Application Ref: 3/2025/0411 - Dene Cottage 9 The Dene Hurst Green BB7 9QF

Proposal: Listed Building Consent for internal and external works. External works to include: replacement of windows and lintels, enlargement of window openings, infill doorways and windows, demolition of existing lean-to and erection of oak framed porch, replacement of roof tiles with slates, replacement of cills and mullions, replacement of guttering and downpipes, removal of render and repoint with lime. Internal works to include: replacement of existing staircase, removal of partitions, excavation of internal floor to increase head height and replacement of internal floor with limecrete.

HISTORIC
BUILDINGS
& PLACES

Existing ground floor plan

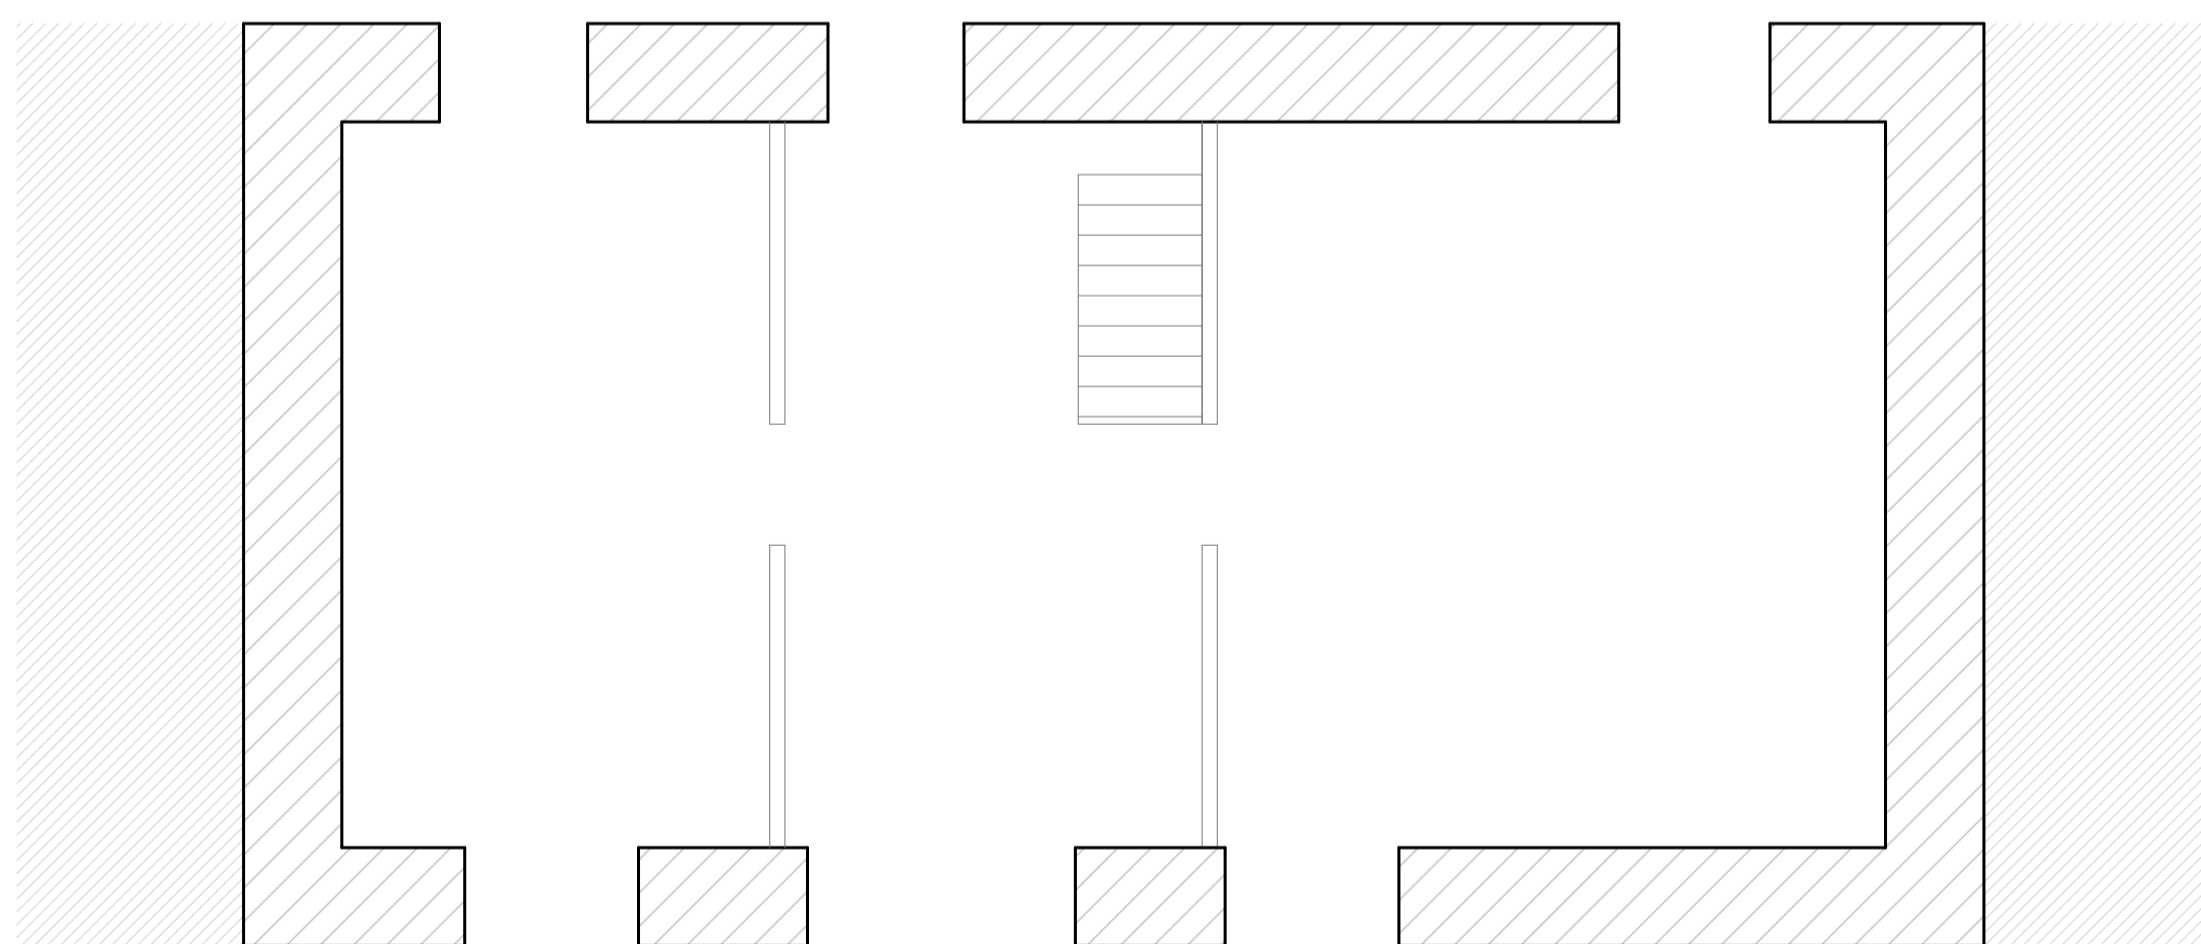
- Images from the sales particulars for the cottage show wood panelling and fireplaces (though not original) and the existing plans do not match those advertised floor plans. Have illegal works taken place? Was any of the panelling or partitions of historic interest?

Proposed first floor plan

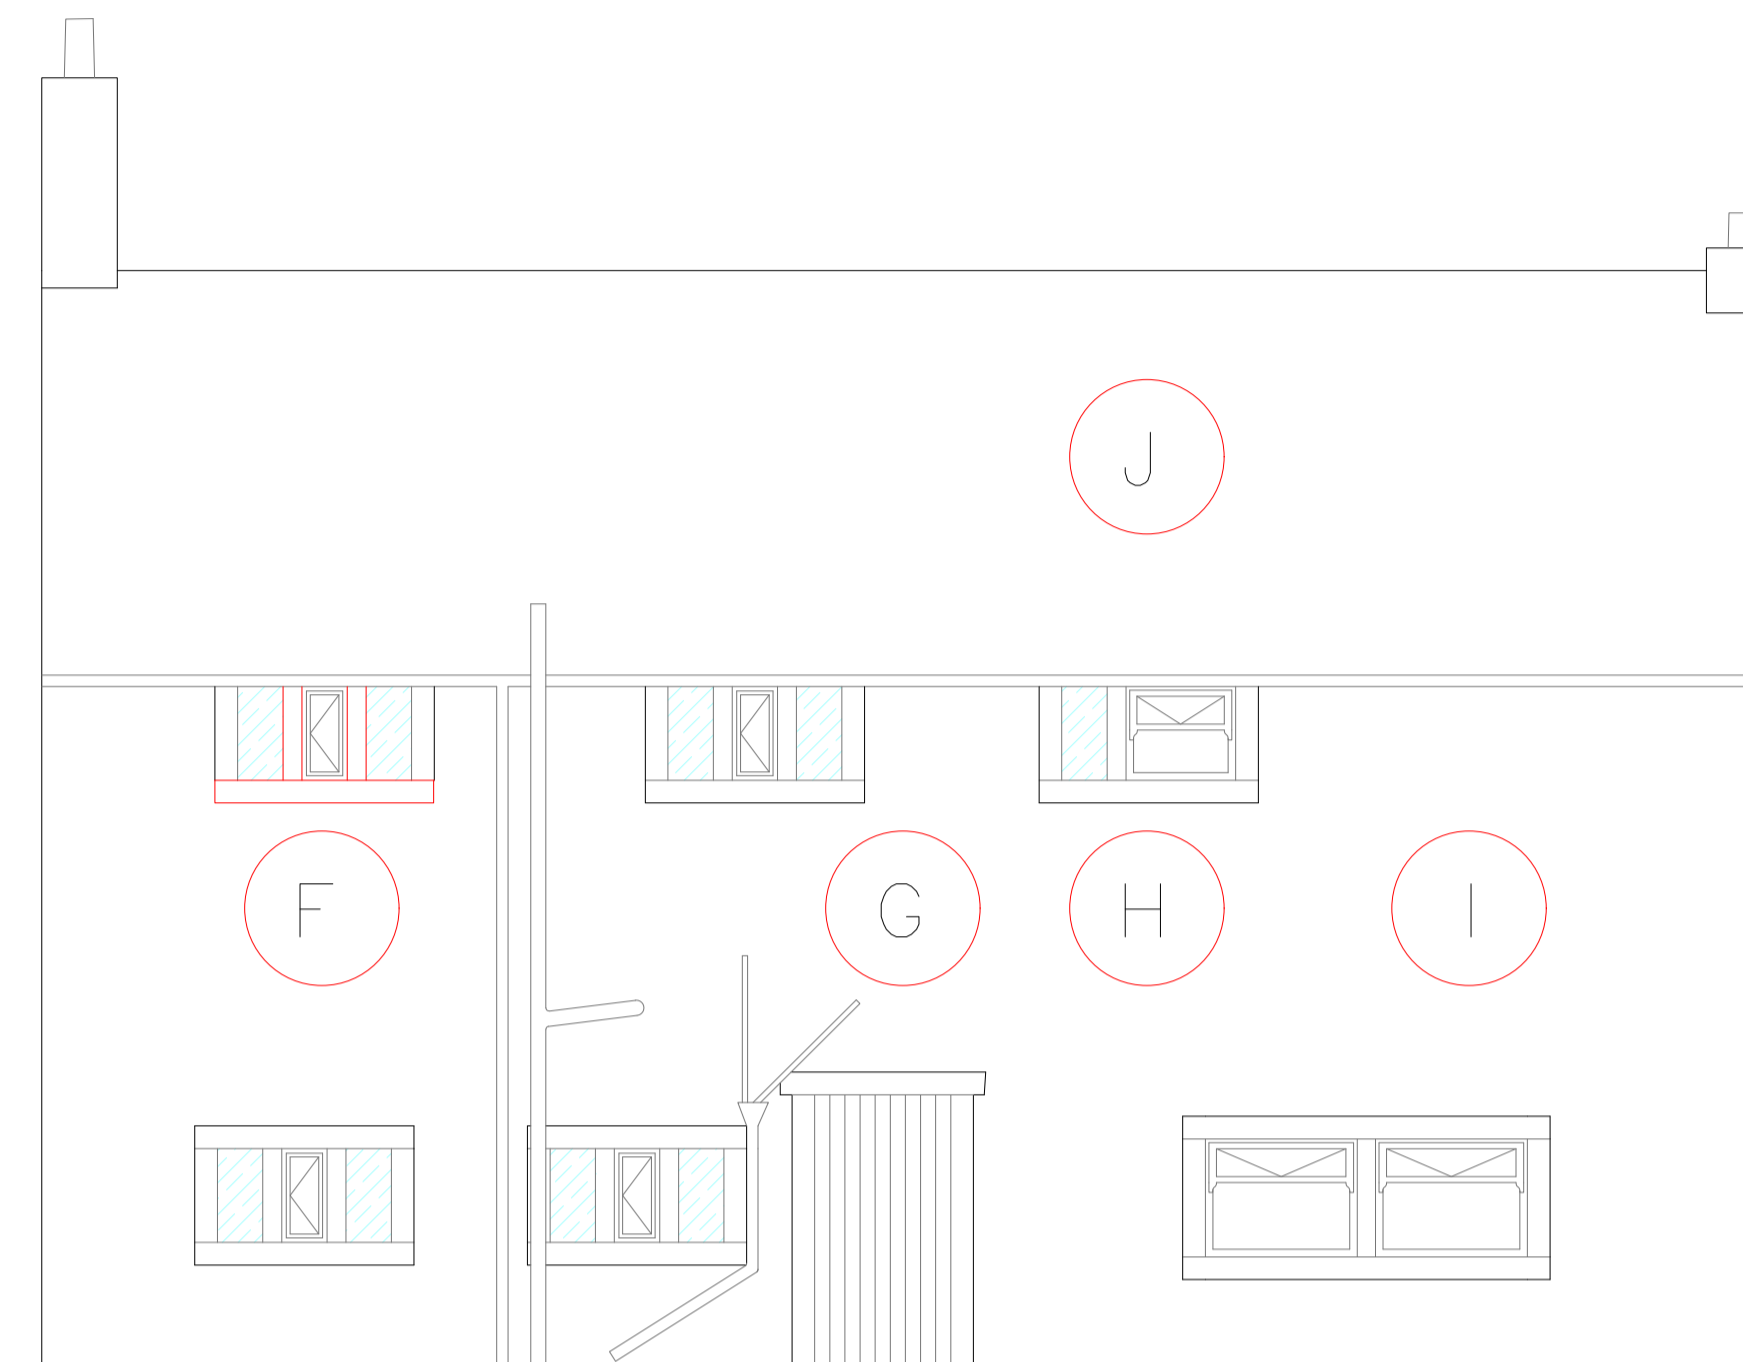
- HB&P acknowledge the stair needs altering to address the lack of landing at first floor. However, details are needed about the replacement stair – in particular, how much of the surrounding first floor joists and floor will need to be removed to allow for the new stair and head height – will the door to the adjacent bedroom need to be relocated to make room for the stair?
